## Connah's Quay Low Carbon Power Change Notification

Planning Inspectorate Reference: EN010166  
Planning Act 2008 (as amended)  
Revision 00

January 2026

Environmental Statement Volume III Figure 15-8: Zone of Theoretical Visibility - 145 m CCP Absorber Column (including Stack) Height plus 7.4 m Raised Ground Level

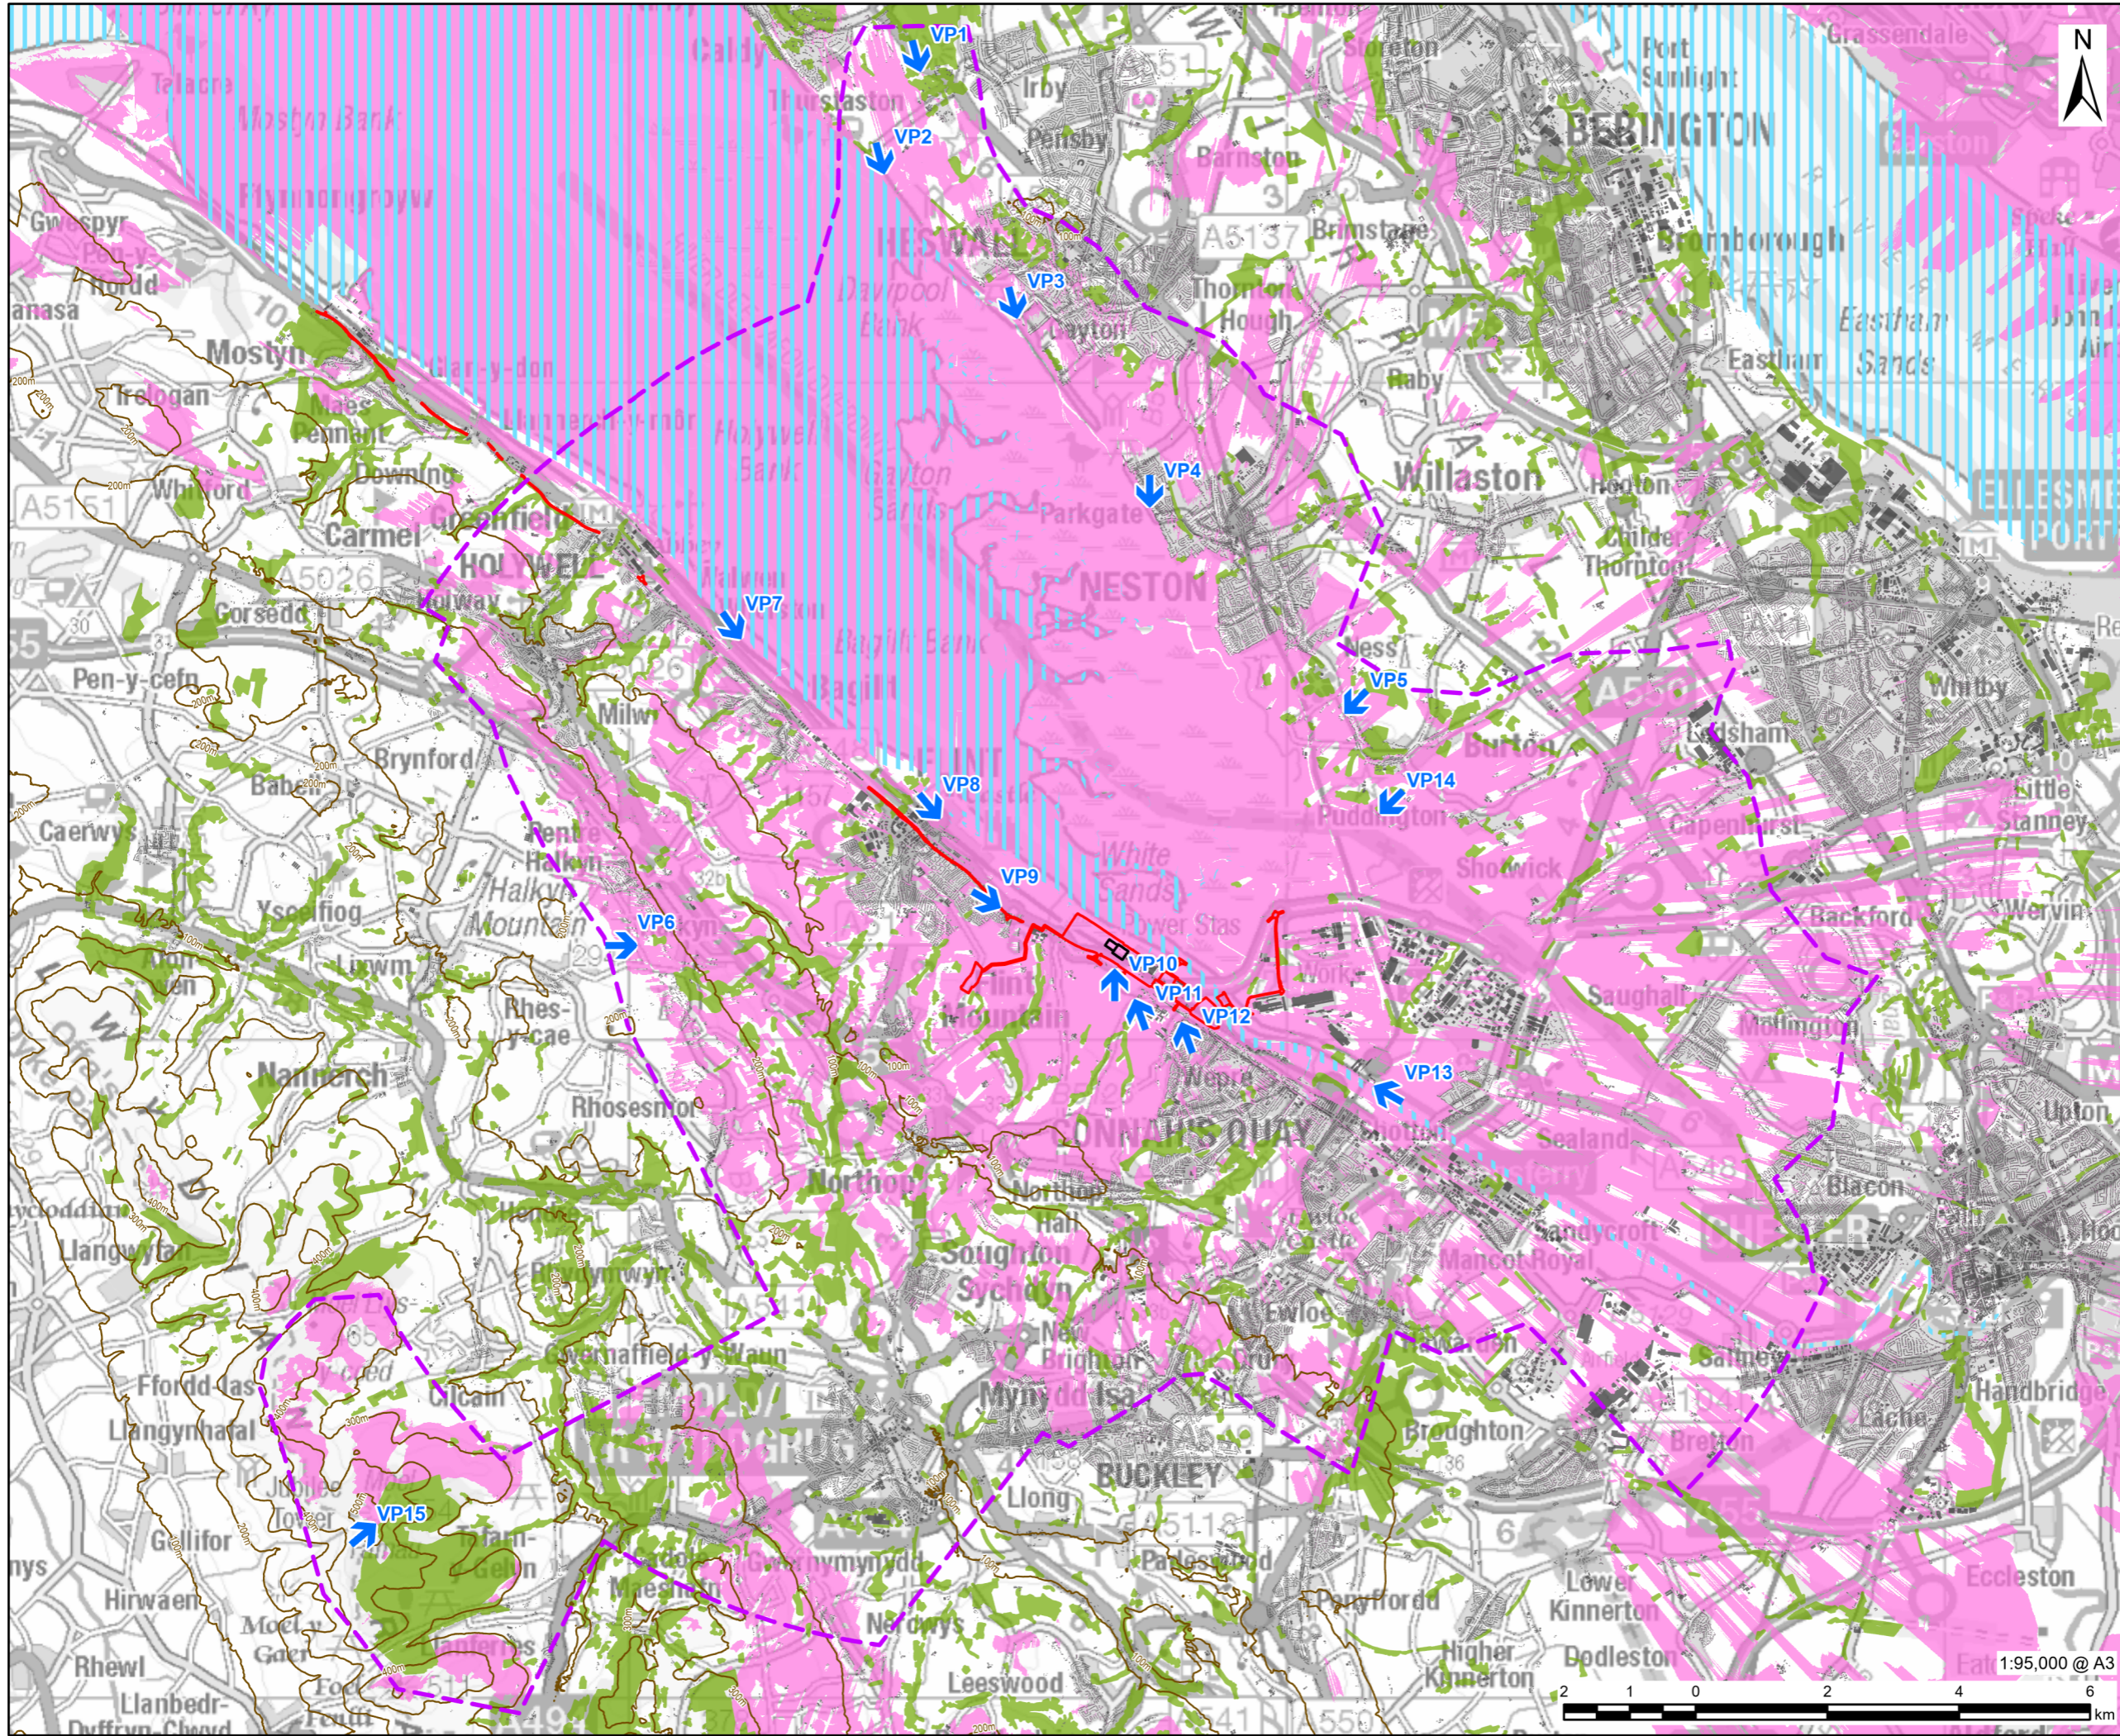
2.5.11 Proposed Change 4 relates to the height of the emission stacks. **Table 2-2** sets out the revised maximum heights of structures in m above-ground level<sup>1</sup> (AGL) for the principal components of the Proposed Development compared to those considered within the ES and presented within the DCO Application.

Zone (see Parameter Plan – Extents*)	Component of the Proposed Development	Maximum Height (m) AGL (see Parameter Plan – Elevations*)		Maximum Height (m) AOD	
		DCO Application at Submission	Proposed Change	DCO Application at Submission	Proposed Change
<b>1A</b>	CCGT Buildings	No Change – 50 m		No Change – 57.4 m	
<b>1B</b>	HRSG Buildings	No Change – 50 m		No Change – 57.4 m	
<b>1B</b>	HRSG Stack(s)	150 m	130 m	157.4 m**	137.4 m
<b>1C</b>	Control, Administration Buildings and Workshops	No Change – 16 m		No Change – 23.4 m**	
<b>1D</b>	CCP Absorbers	150 m	92 m	157.4 m	99.4 m
<b>1D</b>	CCP Absorber Stack(s)	150 m (including stack)	145 m (including stack)	157.4 (including stack)	152.4 m (including stack)
<b>1E</b>	CCP CO <sub>2</sub> Stripper	No Change – 65 m		No Change – 72.4	
<b>1F</b>	Cooling and CO <sub>2</sub> Compression Infrastructure	No Change – 25 m		No Change – 32.4	
<b>1G</b>	Proposed CO <sub>2</sub> AGI	No Change – 6 m		No Change – 13.4
